Fwd: Gilman st parking spots

Tue, Jan 5, 2021 at 10:34 AM

Drawing file: Plans / Gilman SOE - Utility section Rev 12-23-20.pdf

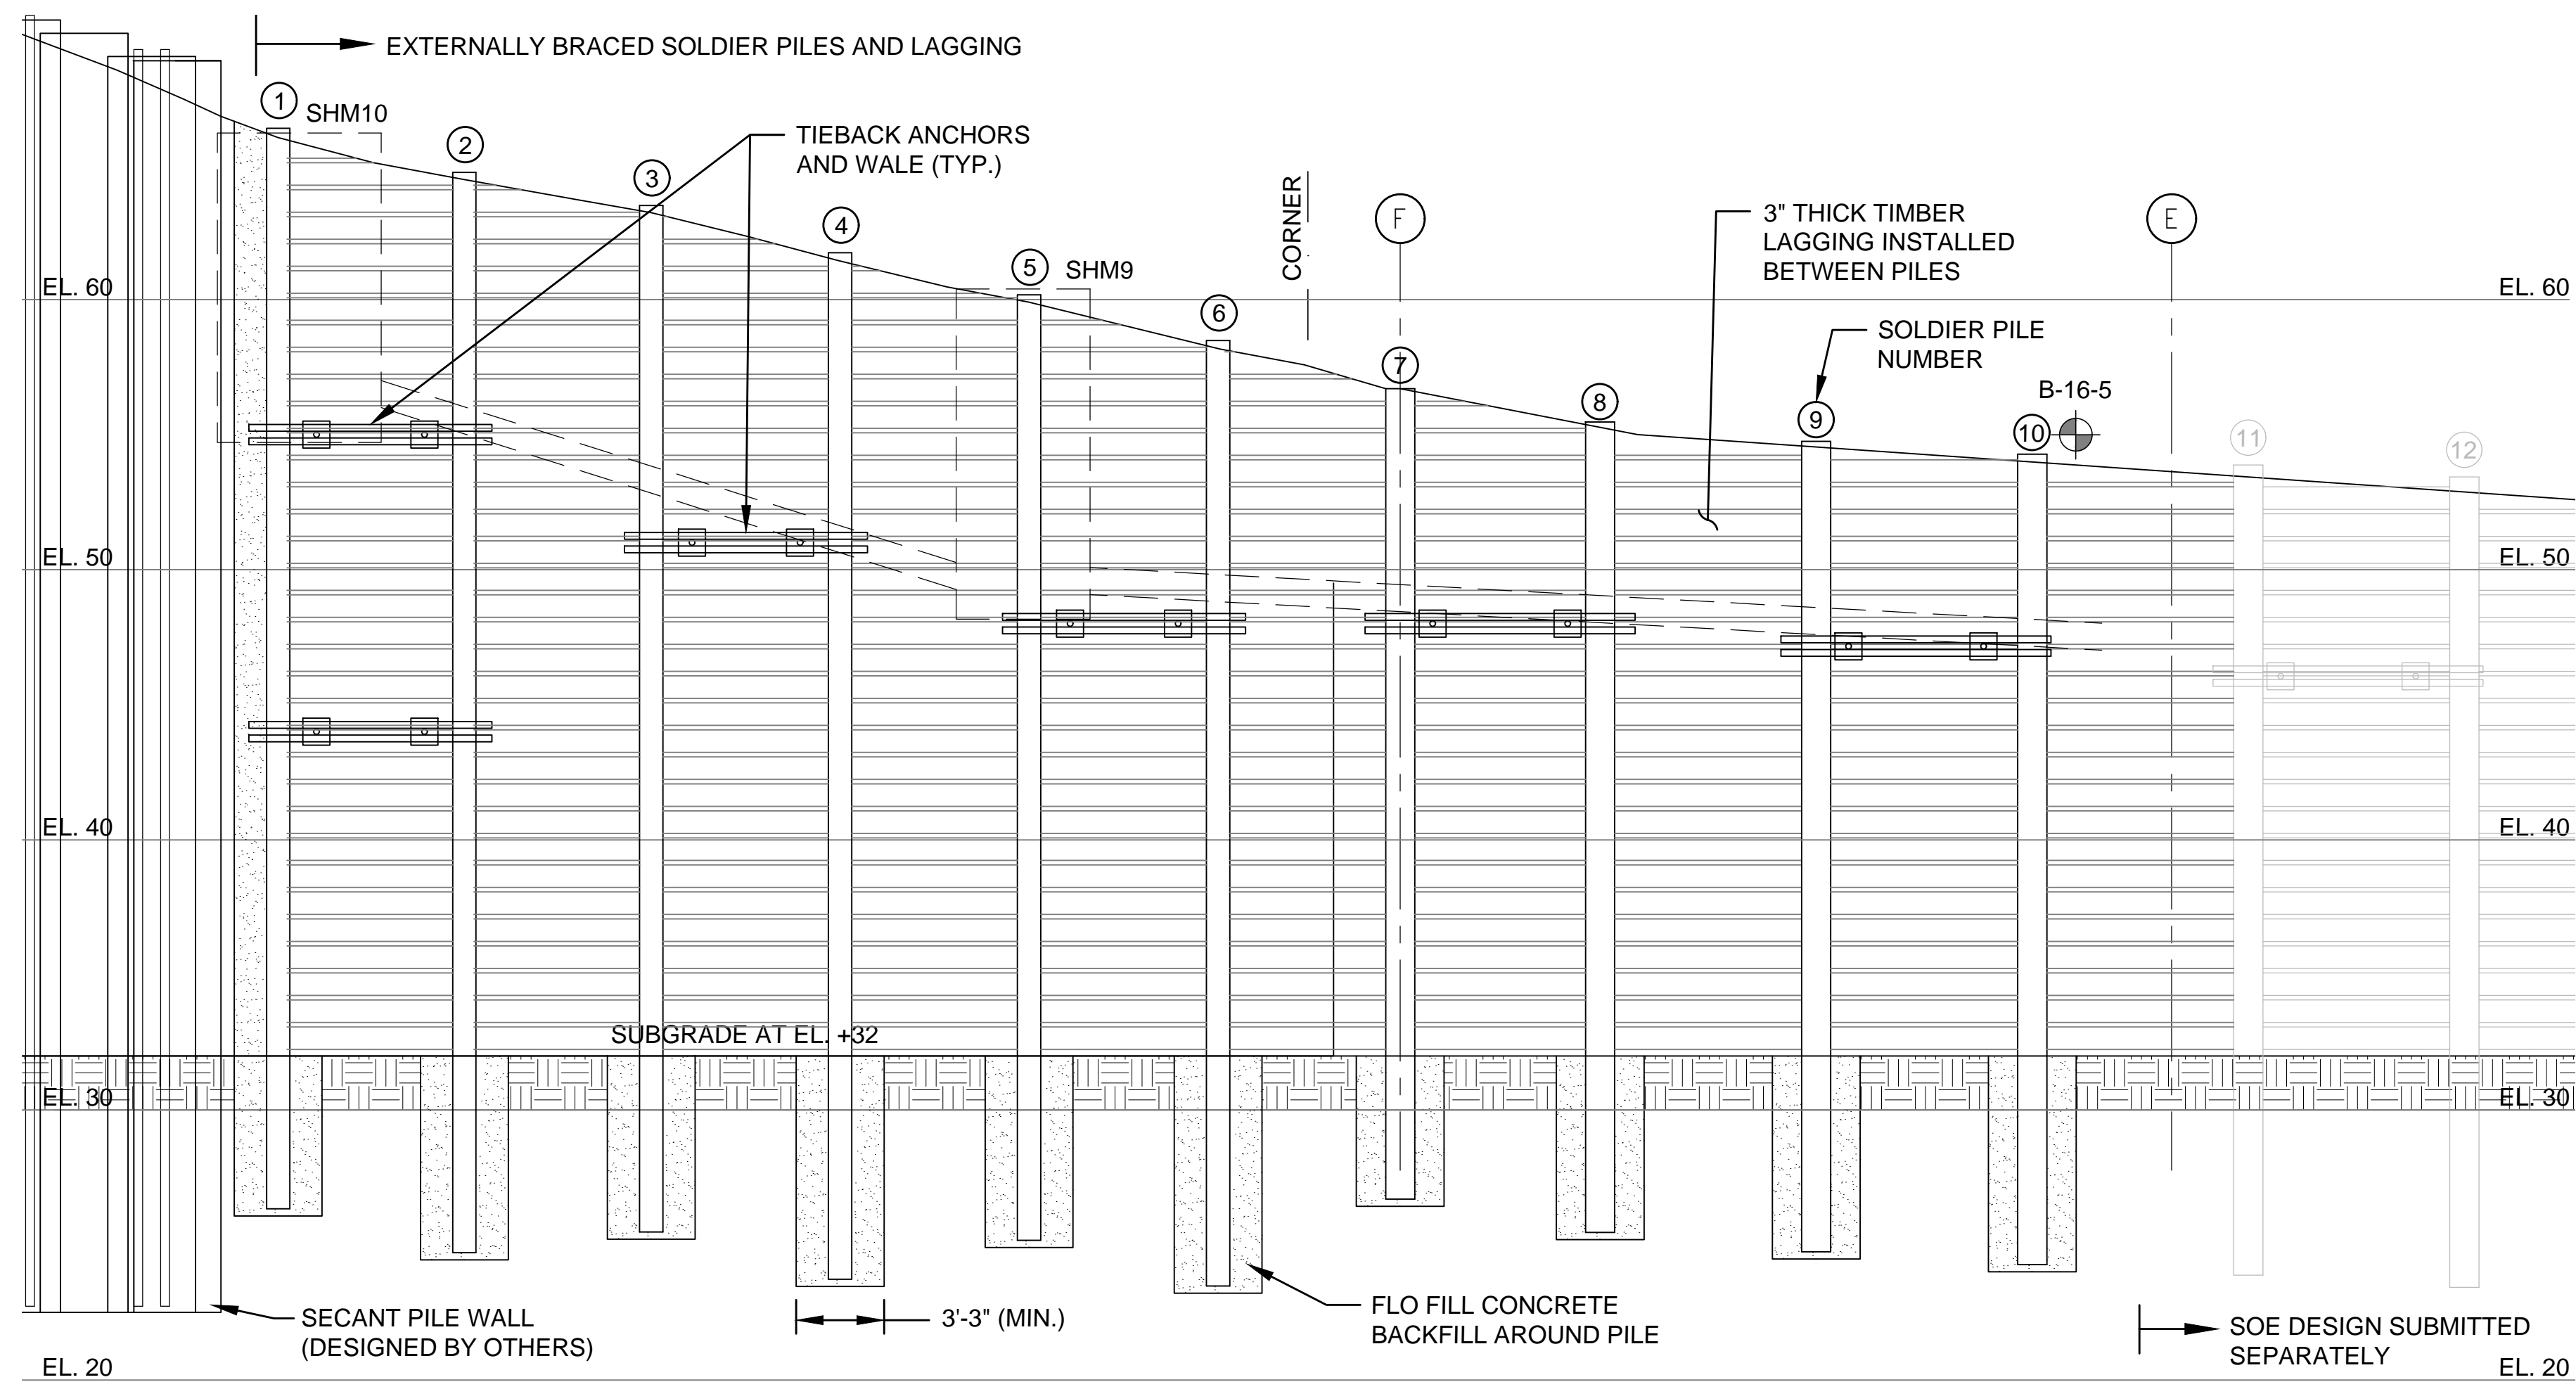
I suspect we'll also want them to pay to camera the sewer line before the tie backs are installed and then again after they are decommissioned. This was my primary concern as well.
